2023 Financial Assurance Estimate Form
(with pre-plat construction)

PROJECT INFORMATION		
MARIAH TRAIL FILING NO. 1	8/4/2023	SF2315
Project Name	Date	PCD File No.

**OWNER SIGNATURE (THOMAS KIRK, JR.)** \_\_\_\_\_ **DATE** \_\_\_\_\_

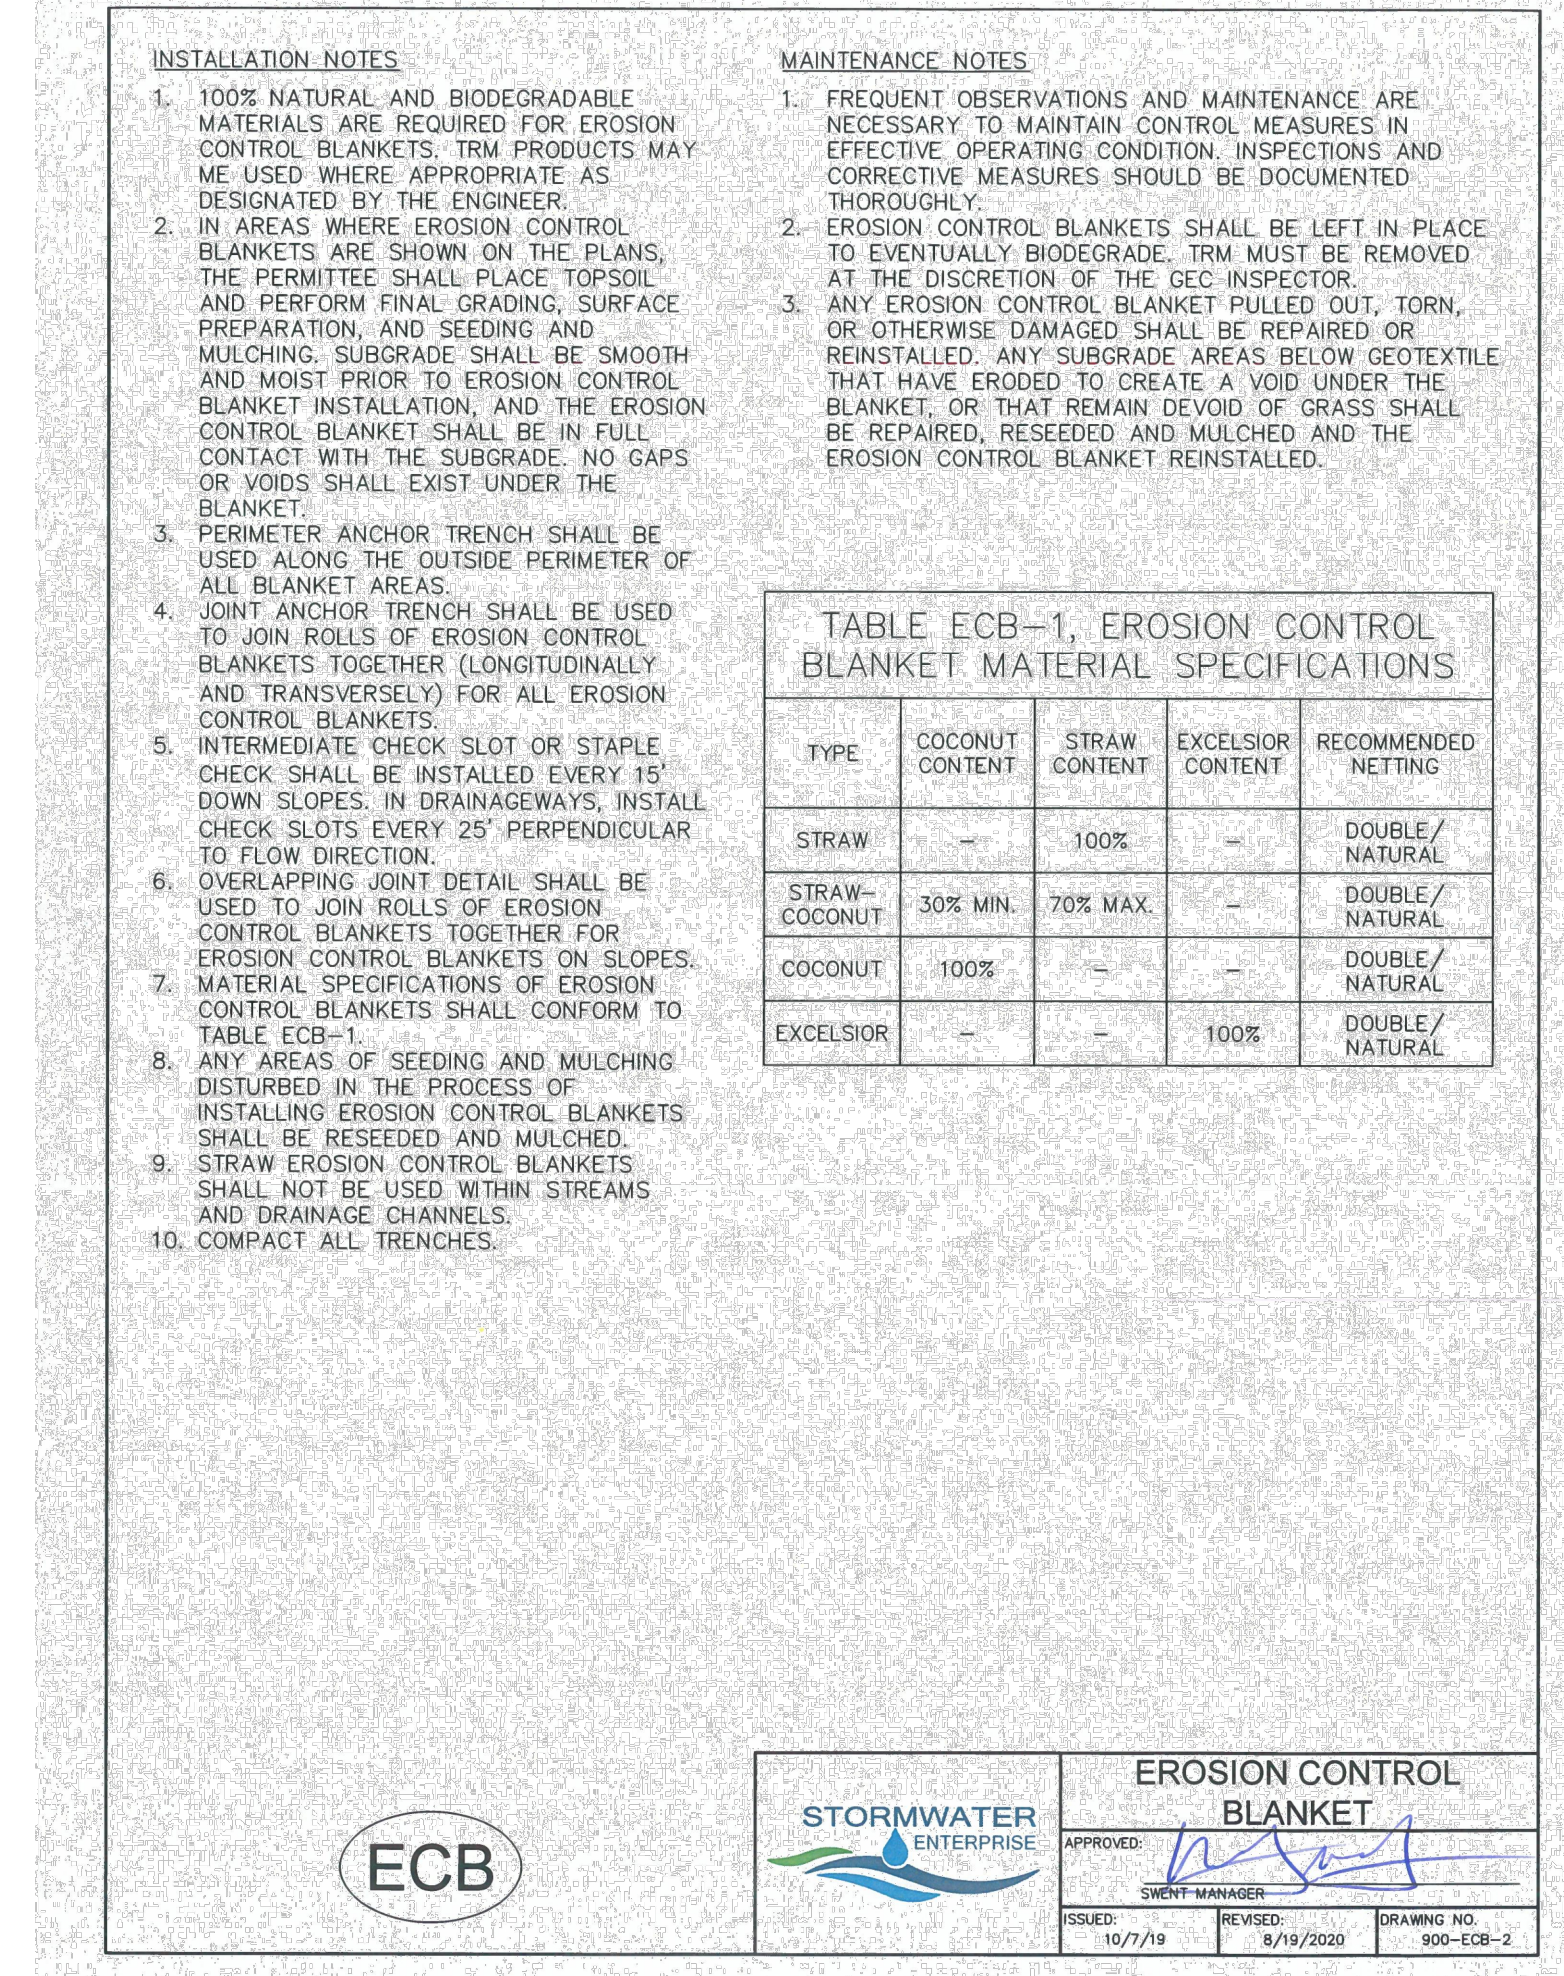
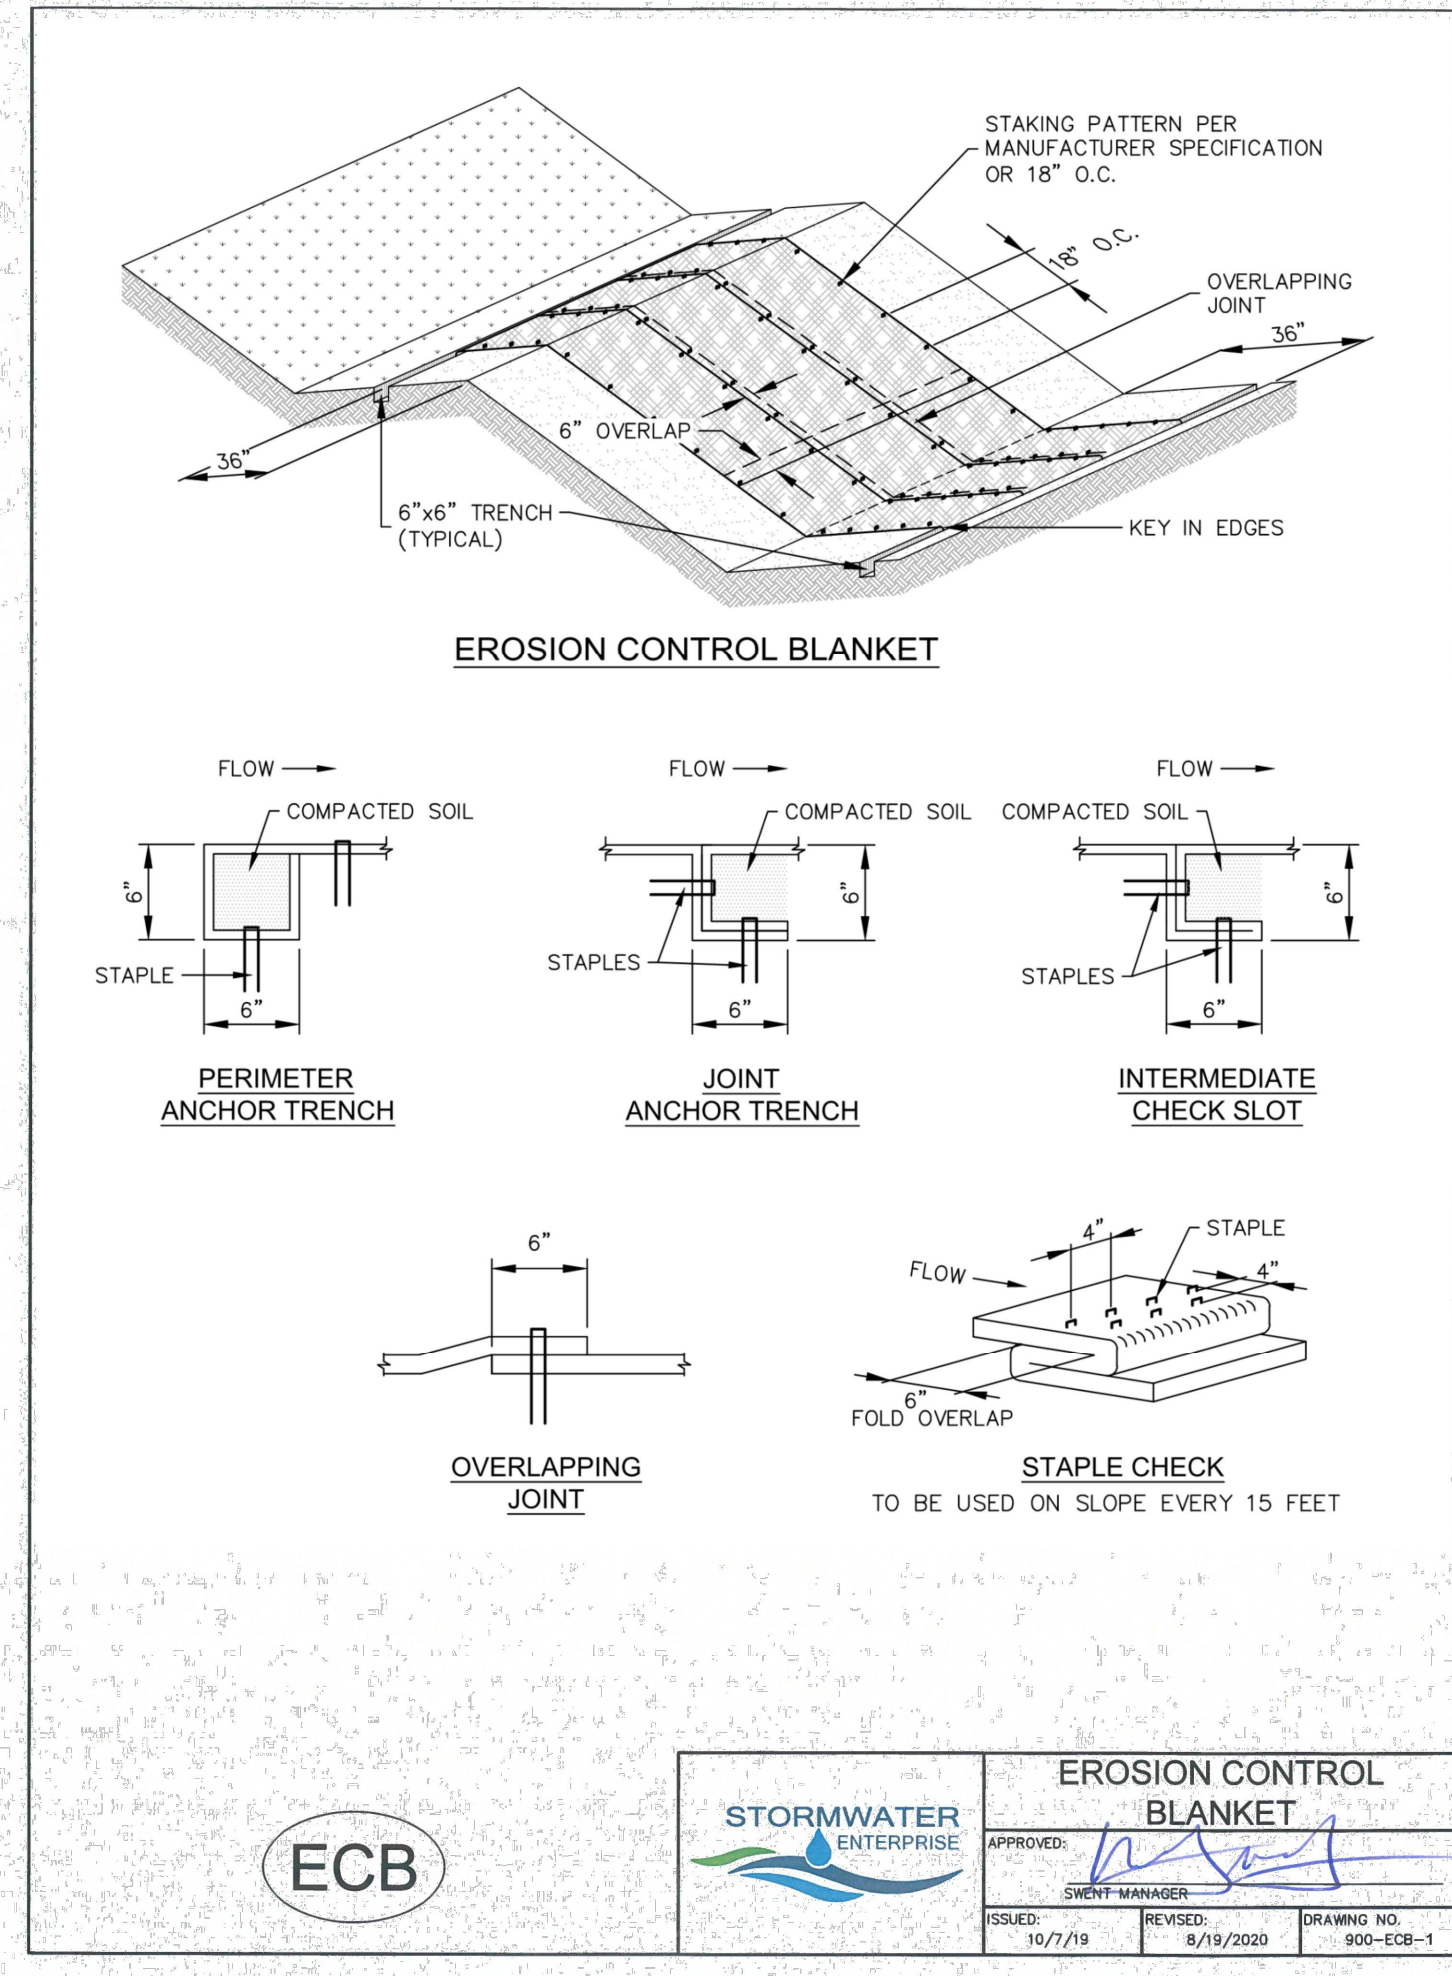
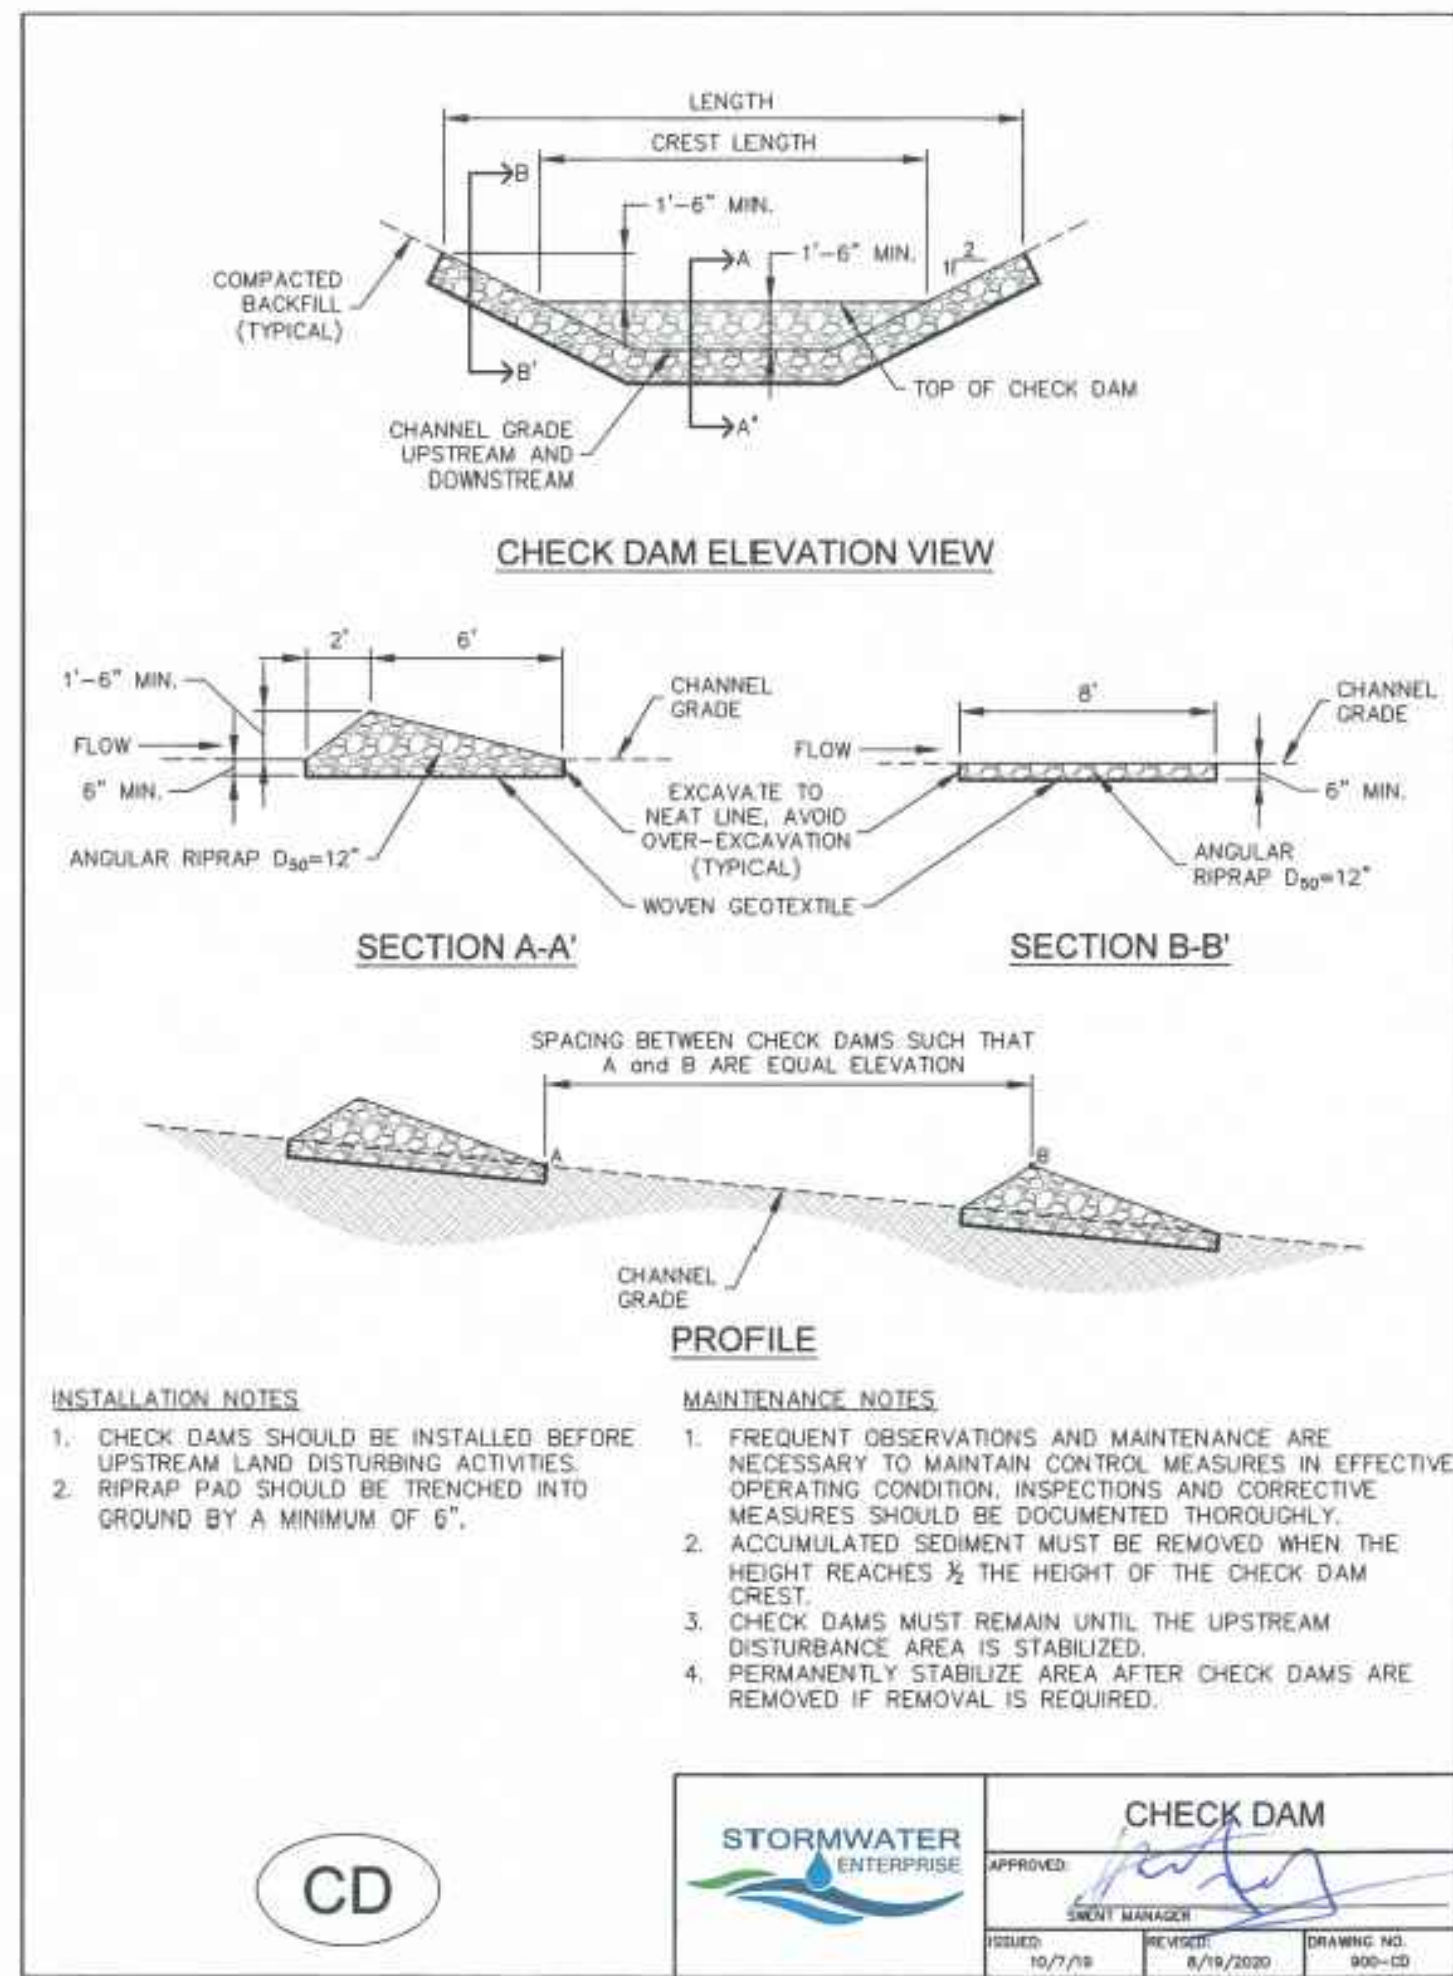
Show CWA on GEC Plan or remove from FAE if unnecessary

Seeding and straw bale barriers not shown on the GEC Plan
